Re: Project 2102-042 6612 SE 24th Street

Response to Intake Screening Notice #2

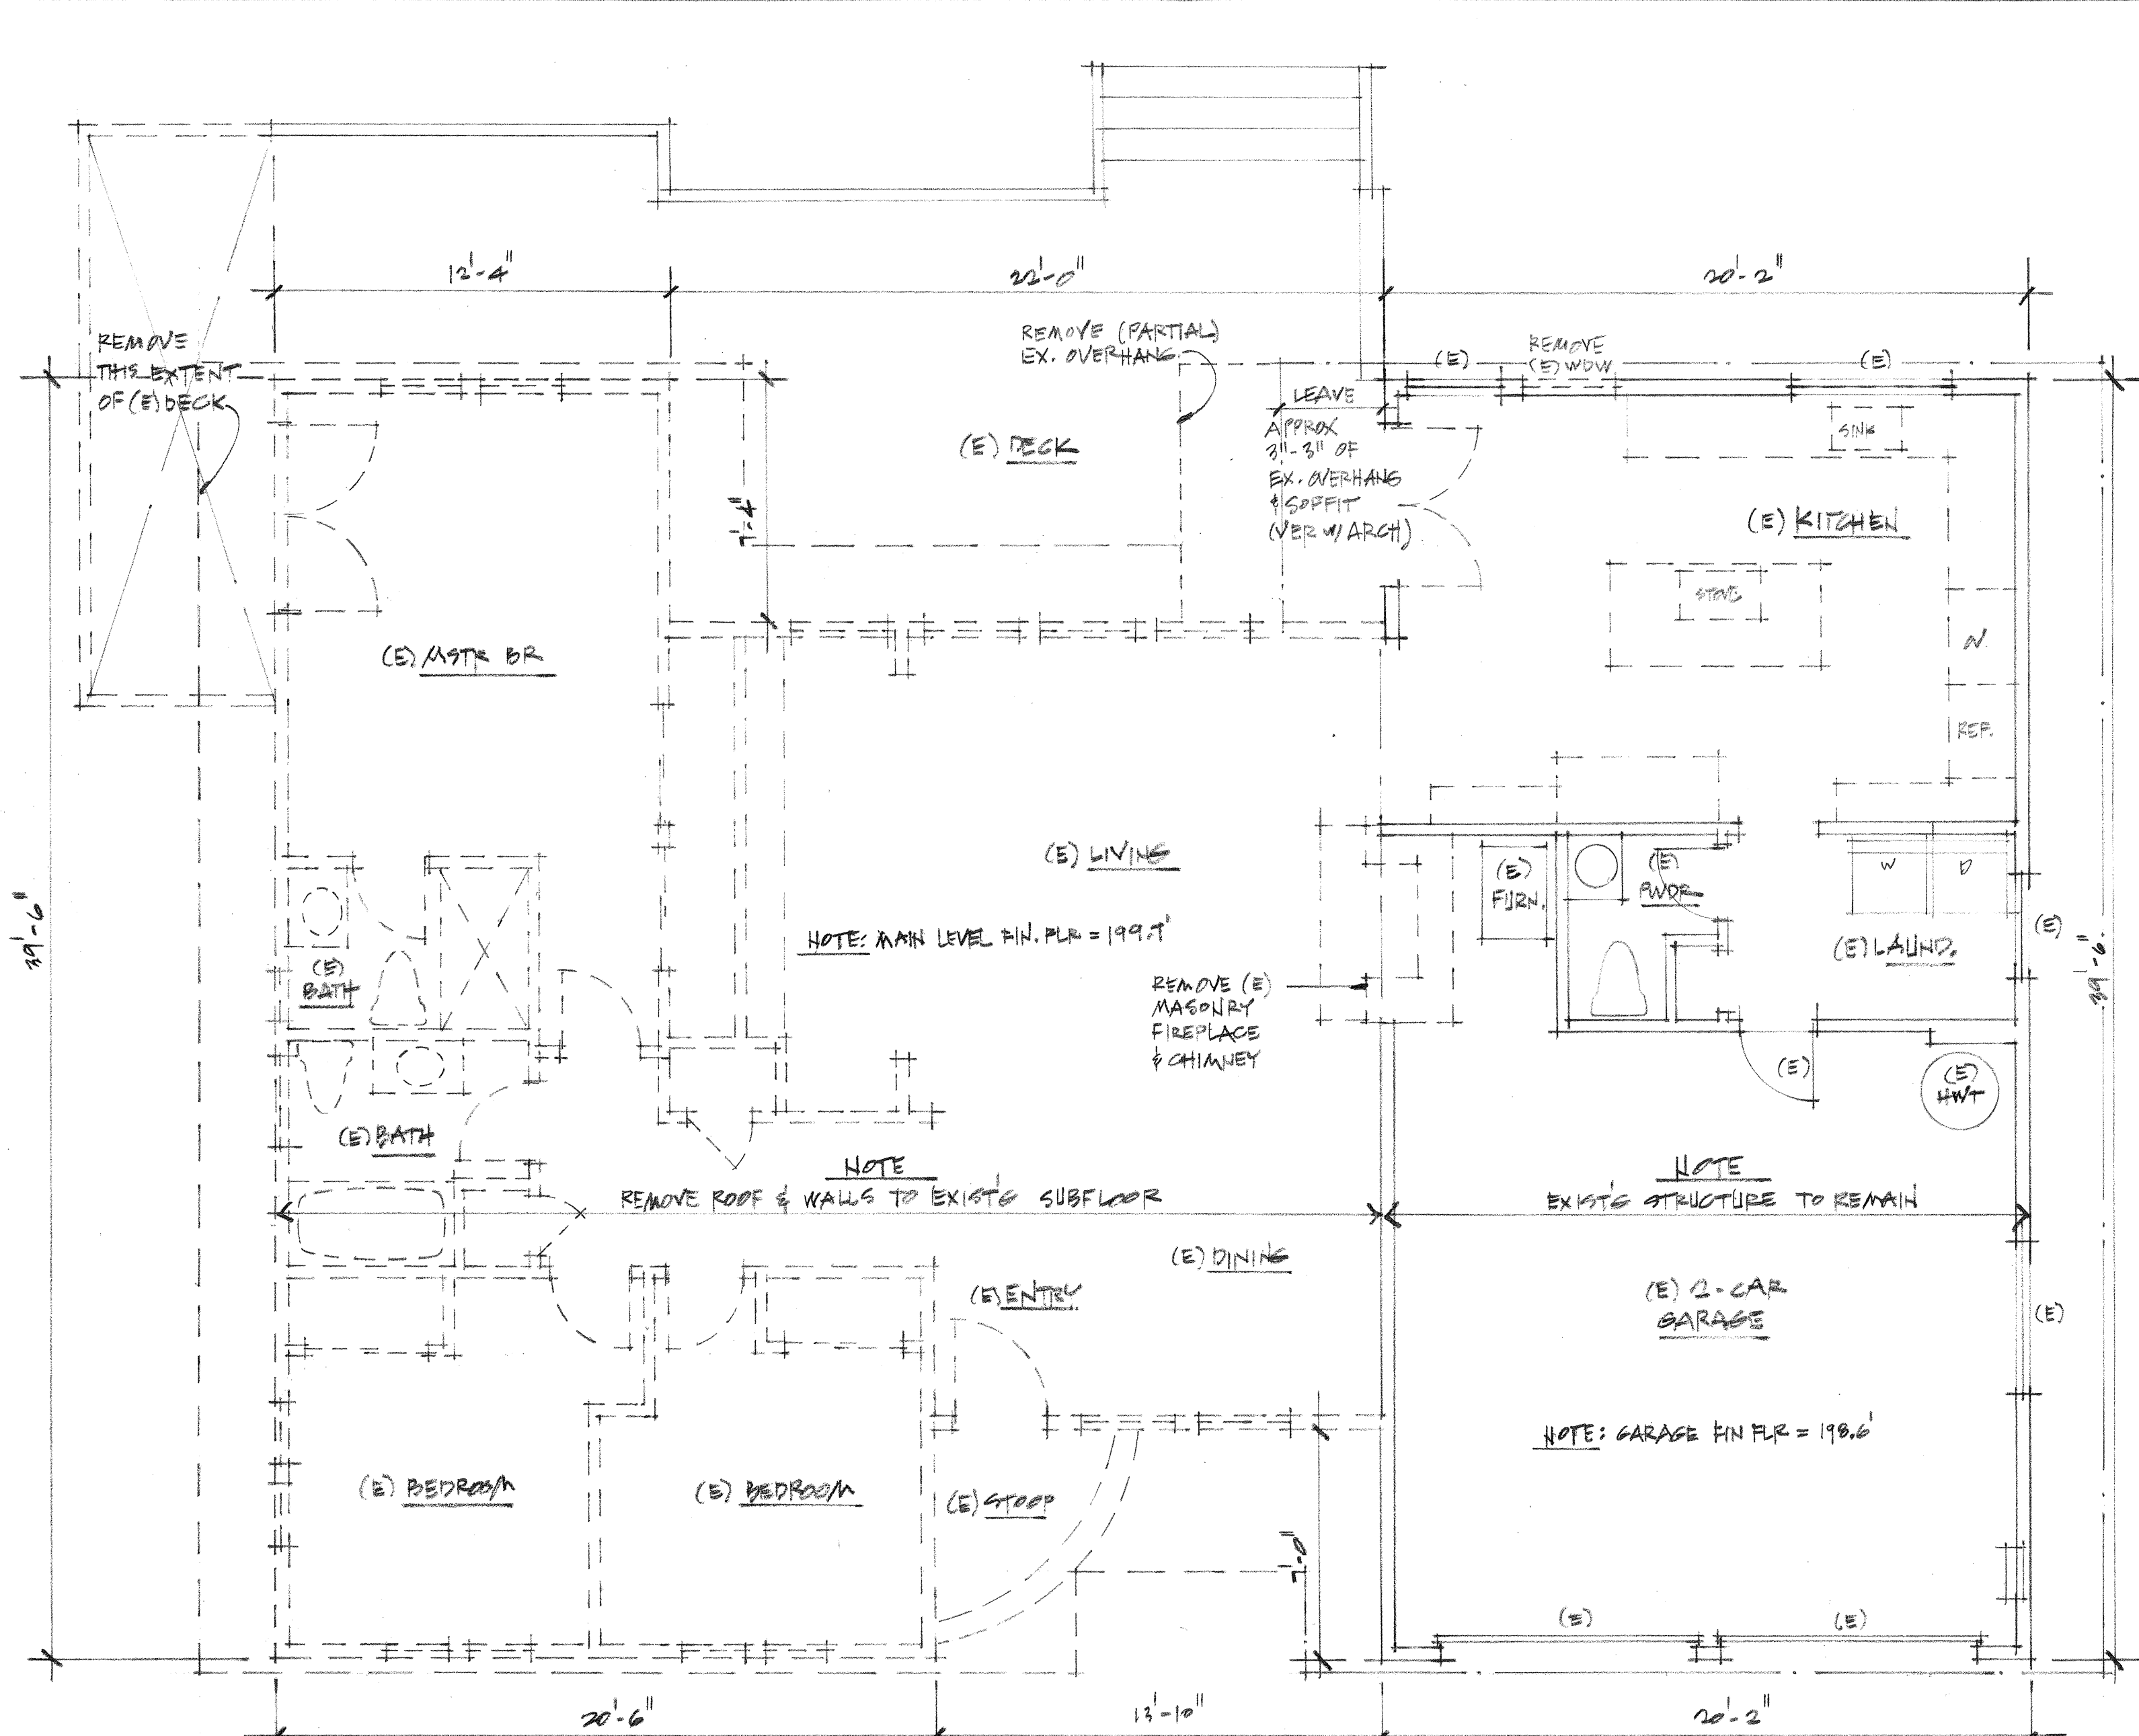
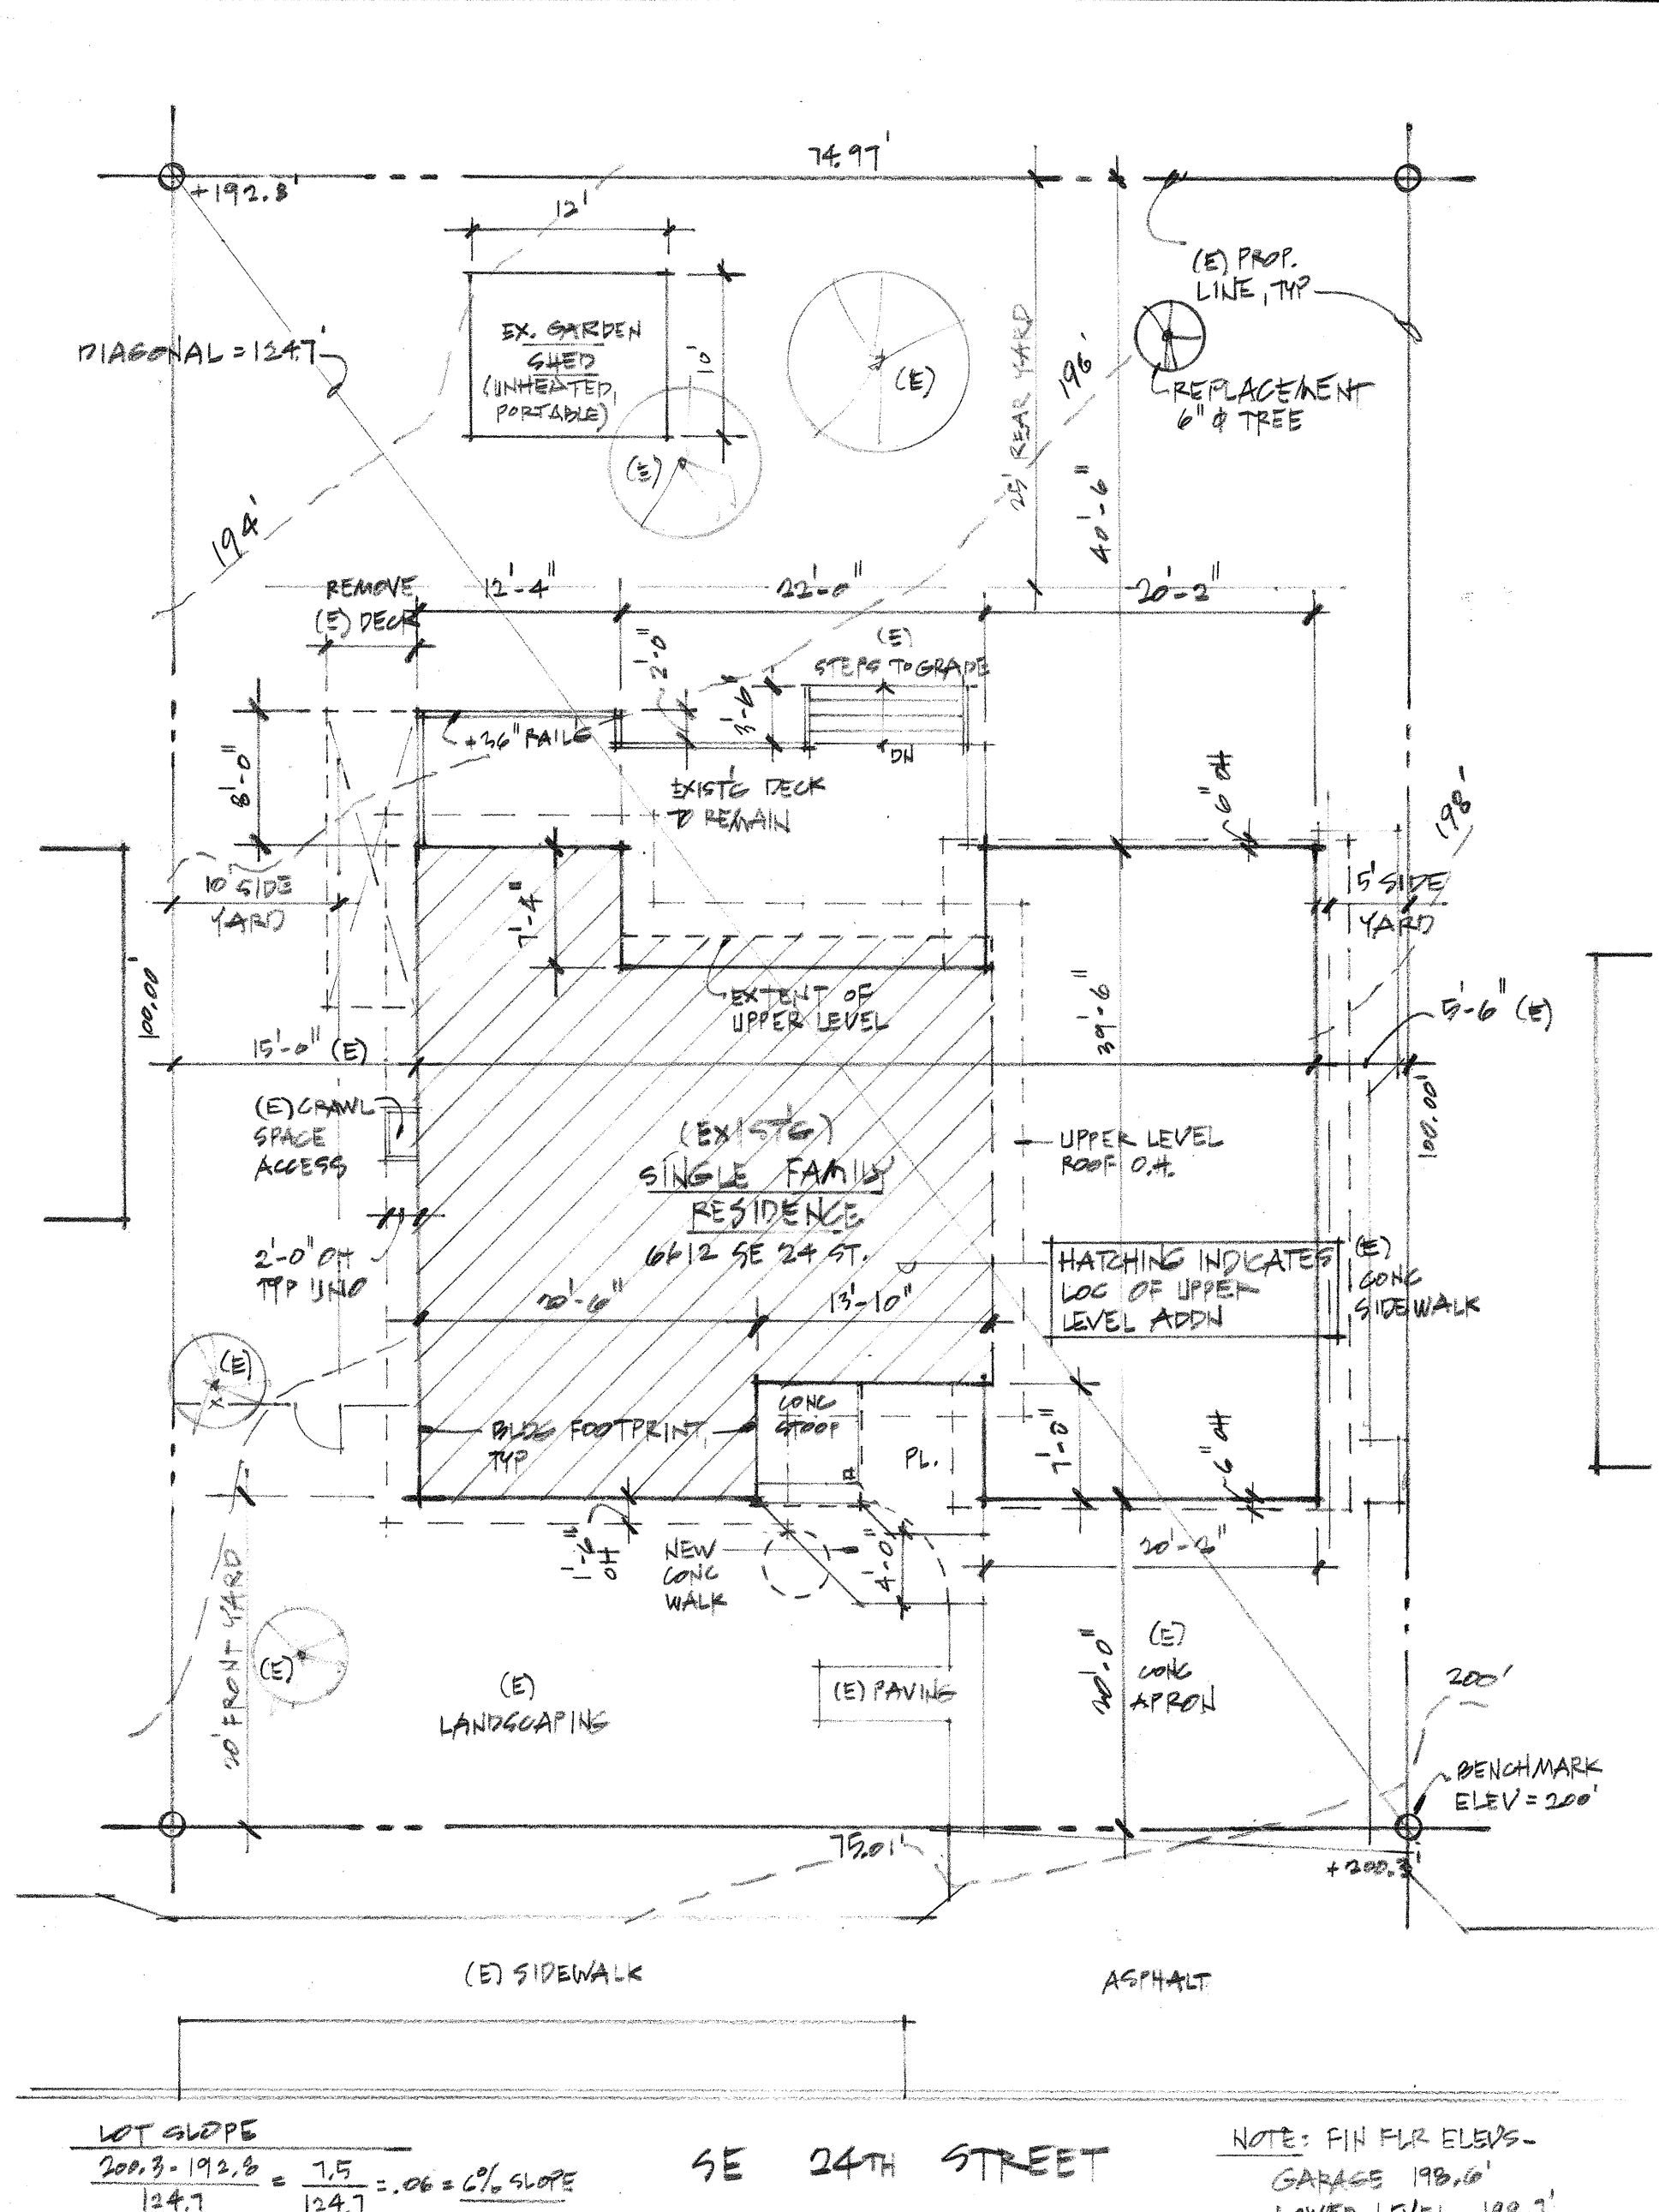
1. See revised Site Plan. Side yard dimensions remain as originally indicated and summary of calculation added.
2. See added Lot Coverage Diagram and calculation.
3. See added Hardscape Diagram and calculation.
